ALTERNATIVE LANDSCAPE PLAN

MONUMENT ACADEMY

SITE DEVELOPMENT PLAN

LANDSCAPE PLAN - AREA 'C'

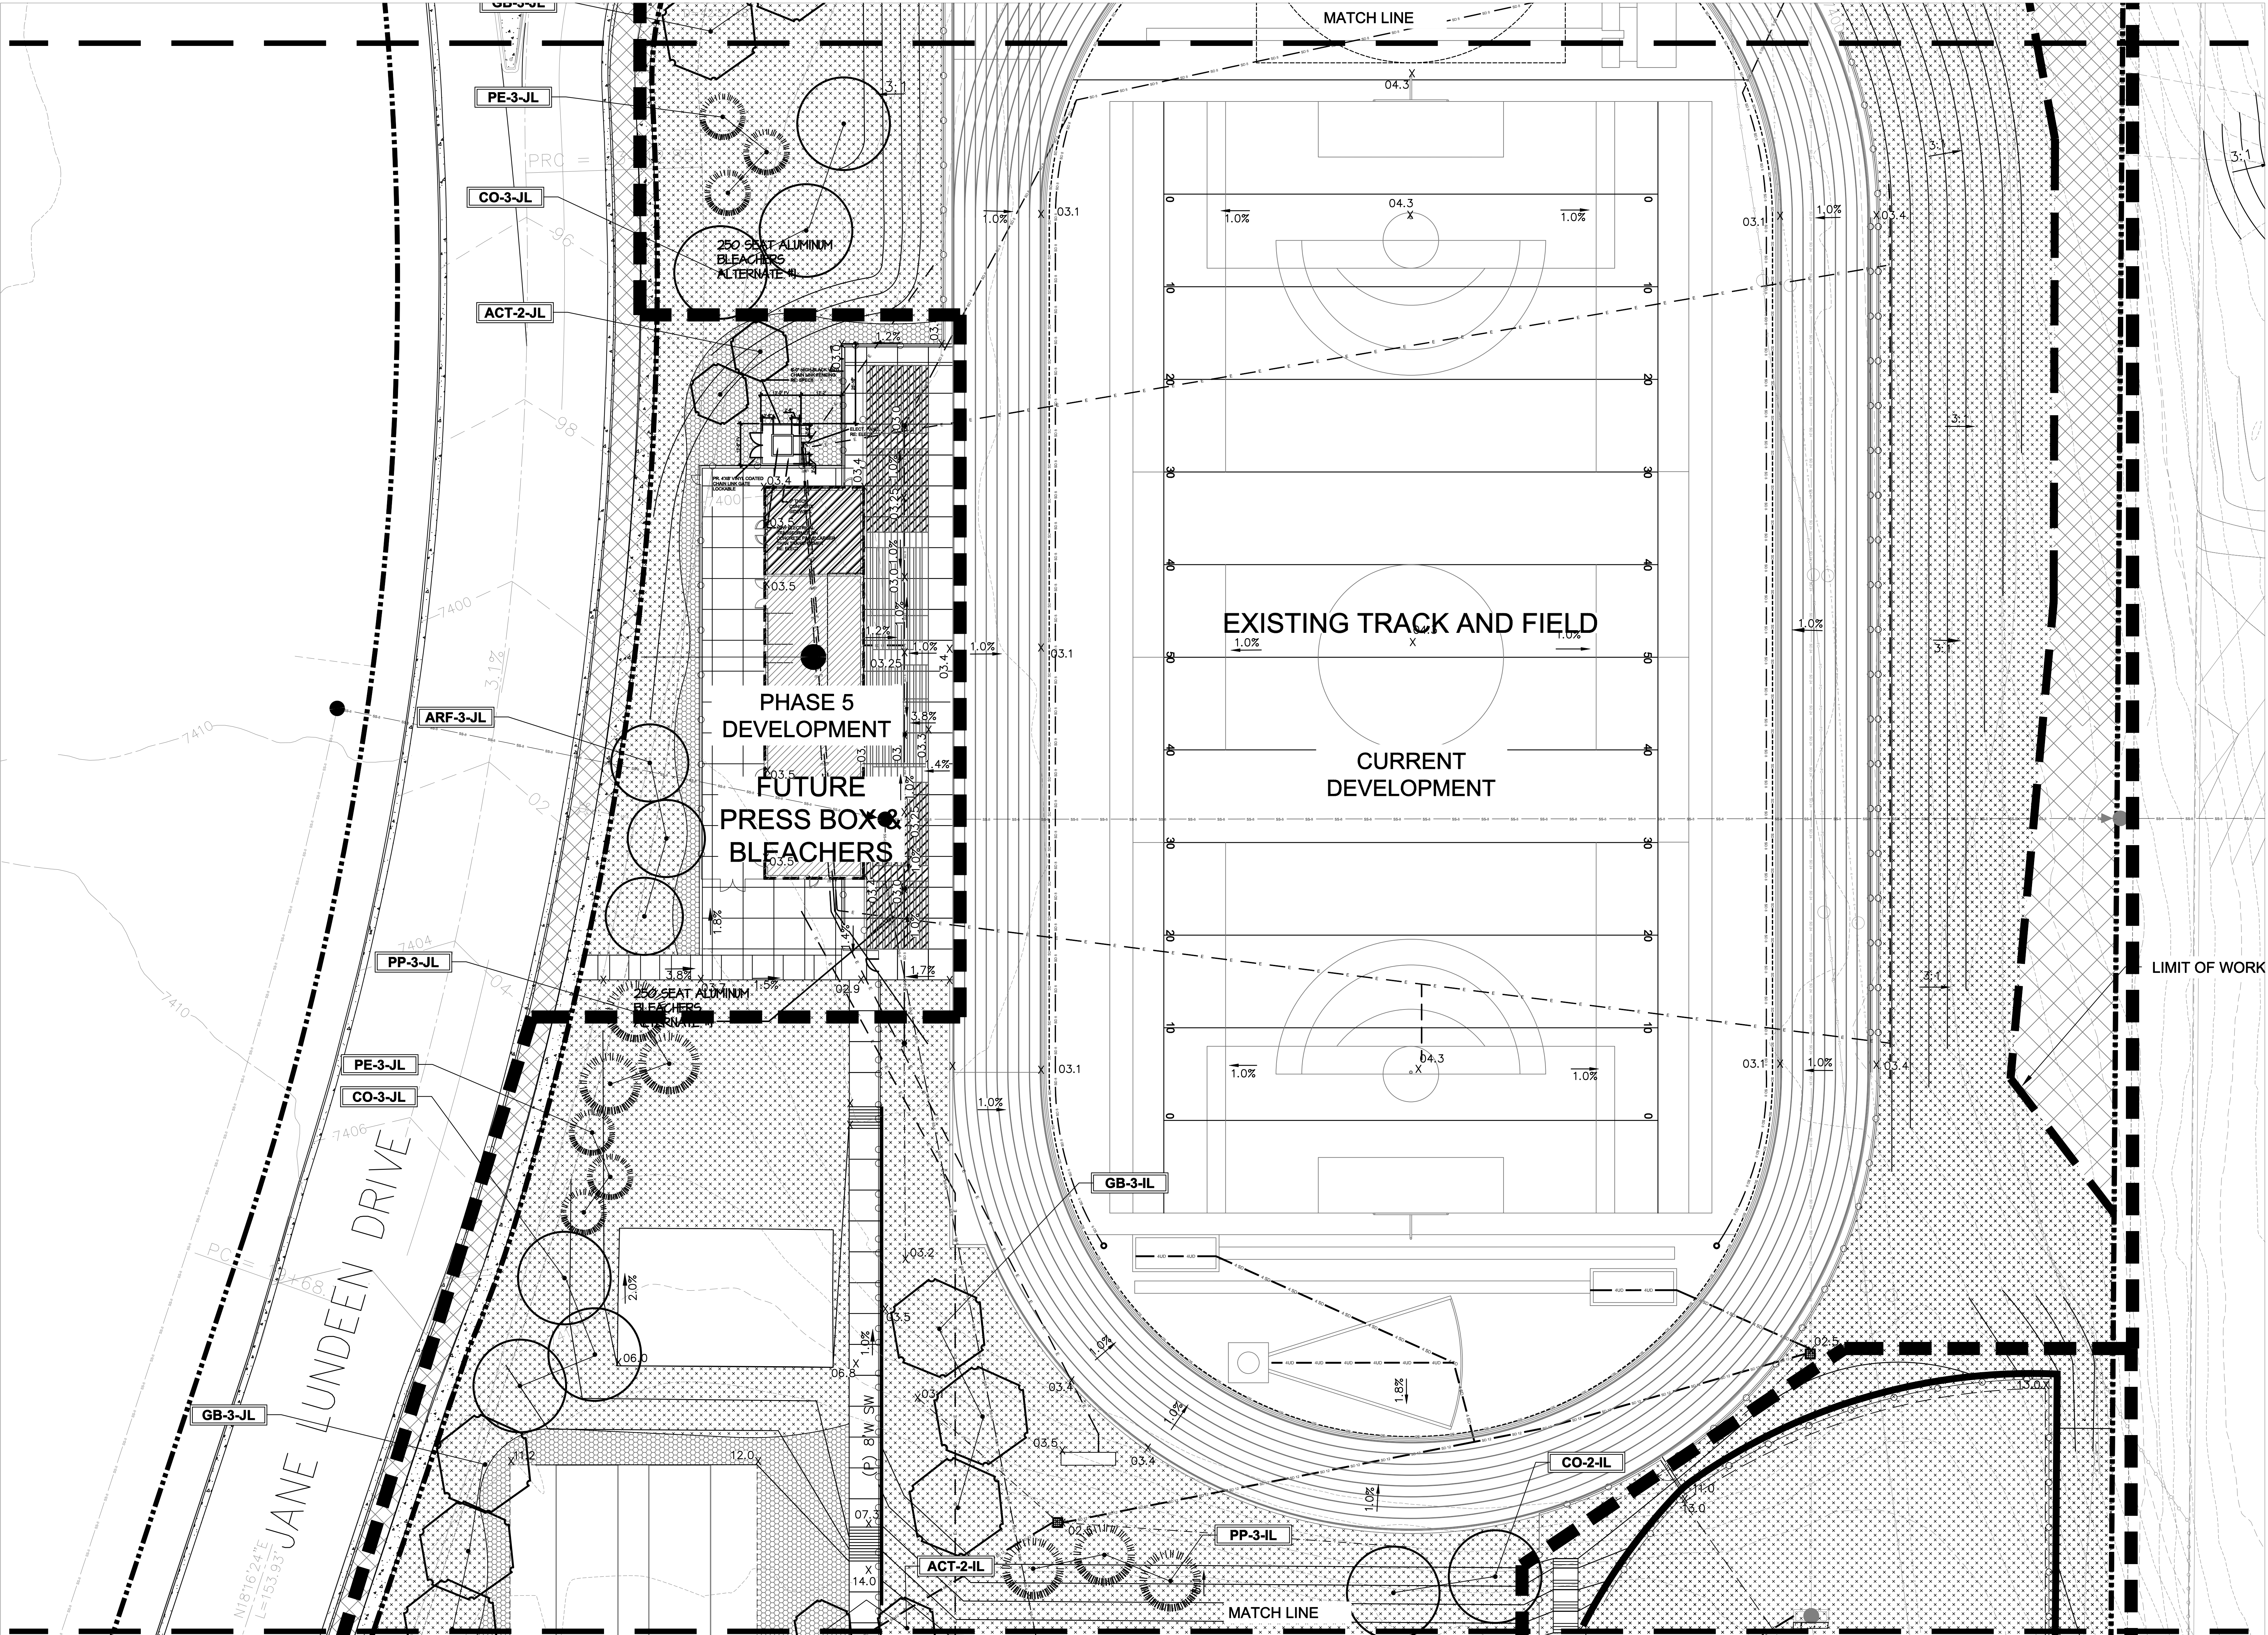
Roadway landscaping and buffer landscaping between uses may overlap. This means that the existing and proposed landscaping along all roadways may also count towards the buffer requirement. The PCD Director does not have the authority to waive a landscape requirement completely. Please update this section of the table to include the buffer requirement and the alternative design that will be proposed, if needed. After reevaluation, this requirement might be met with what is already depicted on the Landscape Plan. If needed, a specific alternative design (not waiver) will need to be requested and described in the Letter of Intent.

The PCD Director does not have the authority to waive landscaping requirements. Also, the previously approved Landscape Plan within PPR199 depicted interior landscaping which met the Code requirements. Please update this section of the table as well as the Letter of Intent.

See Letter of Intent comments regarding substitute design.
